# KITTITAS COUNTY

### MEMORANDUM

**TO:** All Staff  
**FROM:** Public Works Plan Review Team  
**DATE:** March 16, 2026  
**SUBJECT:** AU-26-00002 Engle

A1.0

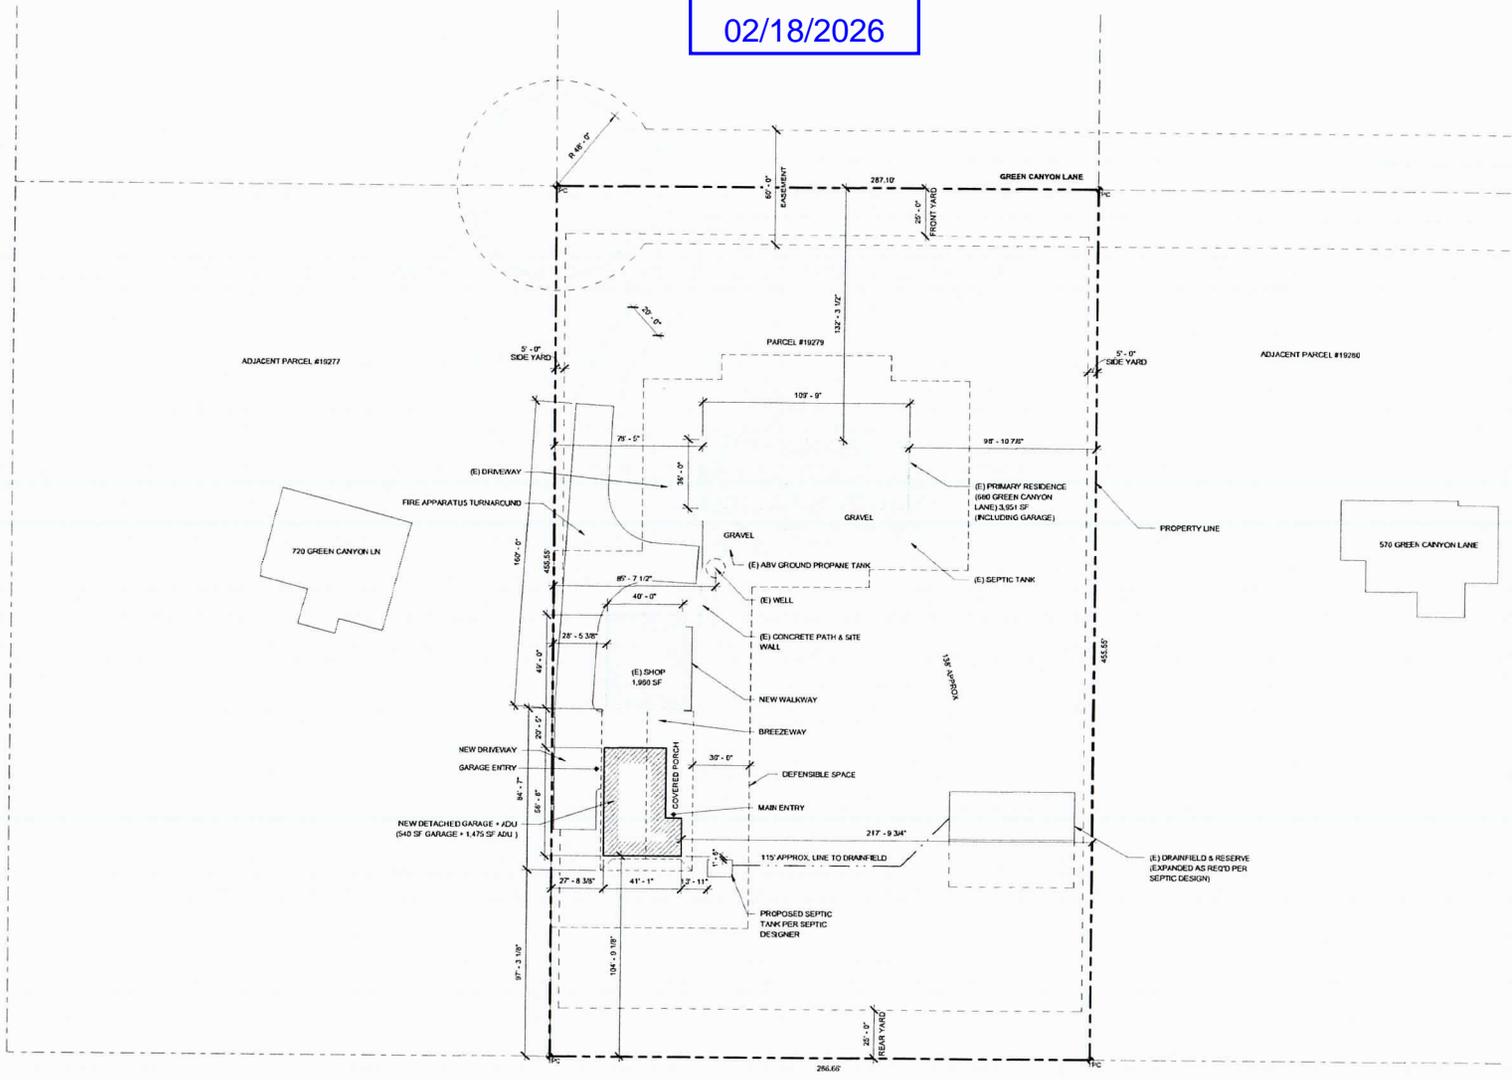
<b>ACCESS</b>	<ol style="list-style-type: none"> <li>1. An approved access permit shall be required from the Kittitas County Department of Public Works prior to creating any new driveway access or altering an existing access.</li> <li>2. Main home and ADU have one shared driveway to ADU and must meet 2024 Kittitas County Code Title 12 requirements for fire, life, and safety.</li> <li>3. Maintenance of driveway approaches shall be the responsibility of the owner whose property they serve. The County will not maintain accesses.</li> <li>4. Any further subdivision or lots to be served by proposed access may result in further access requirements. See Kittitas County Road Standards.</li> <li>5. Green Canyon Ln. is a certified Private Road.</li> </ol> <p>In addition to the above-mentioned conditions, all applicable Kittitas County Road Standards apply to this proposal. Access is not guaranteed to any existing or created parcel on this application.(RC)</p>
